June 7, 2013

**Re: Murphy Express, Carlisle and Phoenix, Conceptual Grading and Drainage Plan**

**Engineer's Stamp Date 5-31-13 (H16/D008A3)**

**GRADING &
DRAINAGE PLAN**

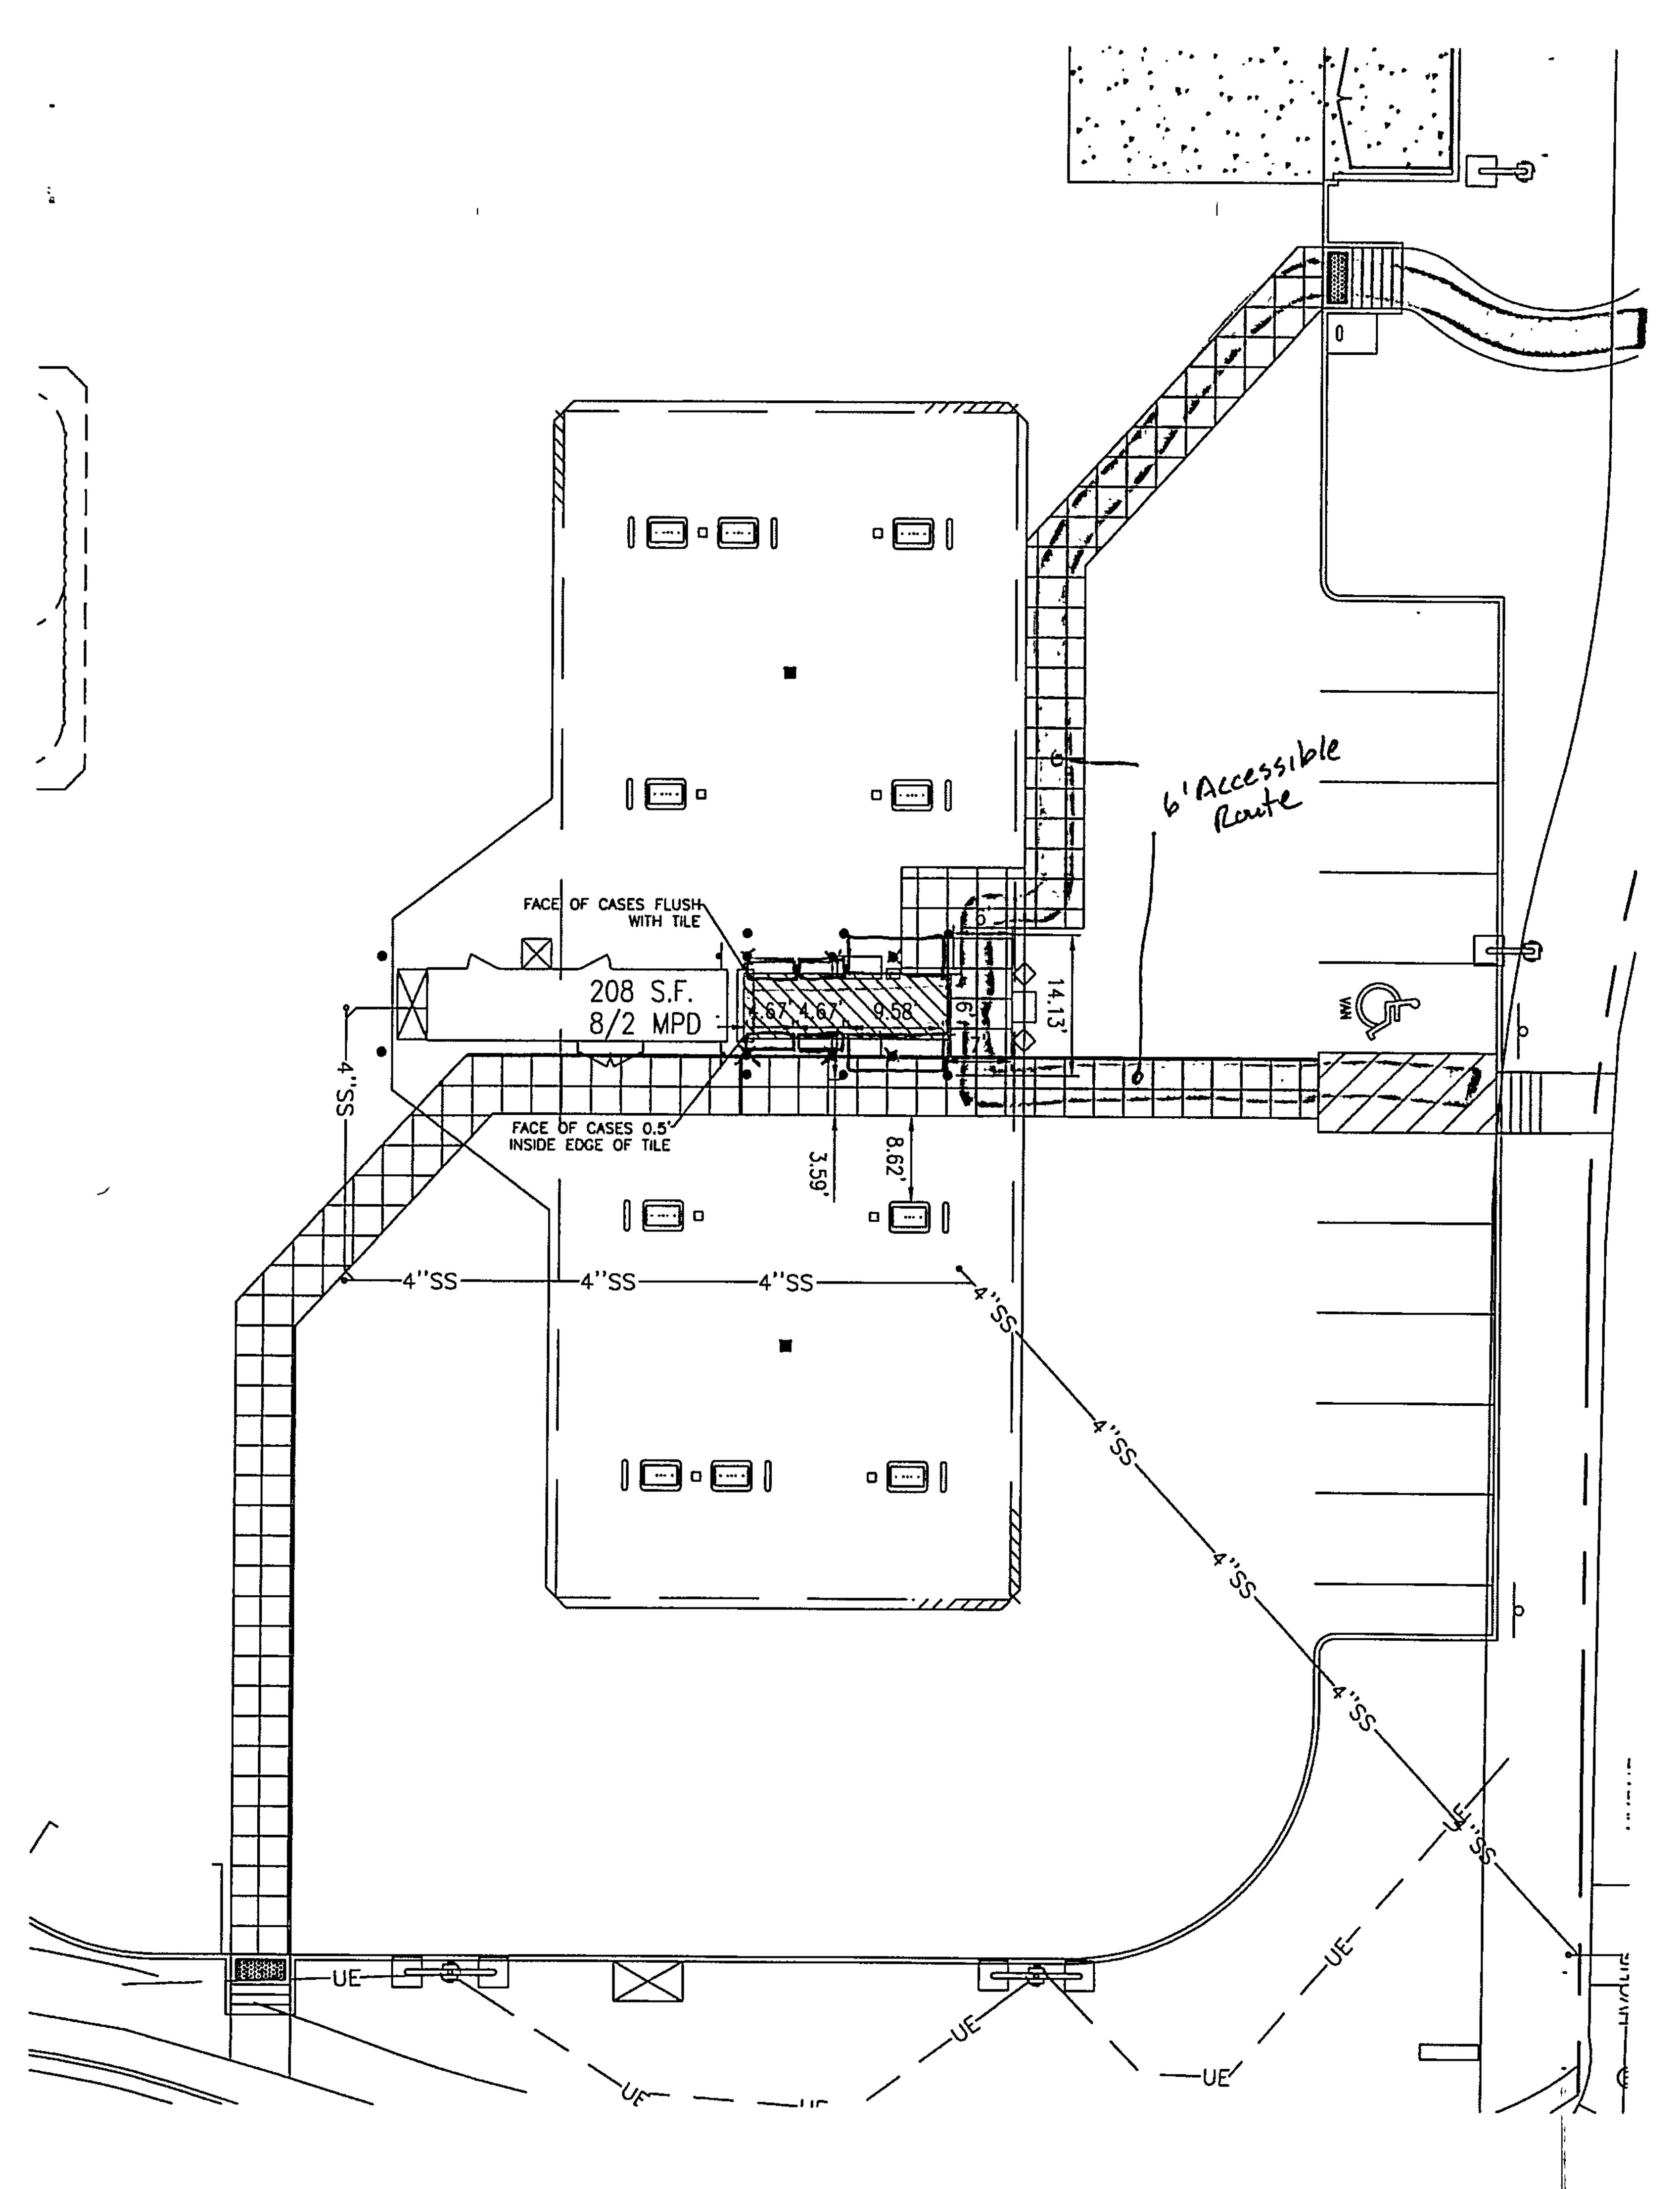
1. Proposed grades show the east half of the site draining through the canopy area. The area under the canopy is to be perched and have an isolated storm drain that drains to the oil/water separator to minimize the potential for pollutants to enter the City storm drain system that drains to the river.

Perching the canopy area may also negate the need for a long trench drain that could be replaced with a couple of area inlets.

The finished floor elevation may have to be increased one foot or so. I have included a rough mark-up that I used to evaluate the effect of the increase in grade of the canopy area.
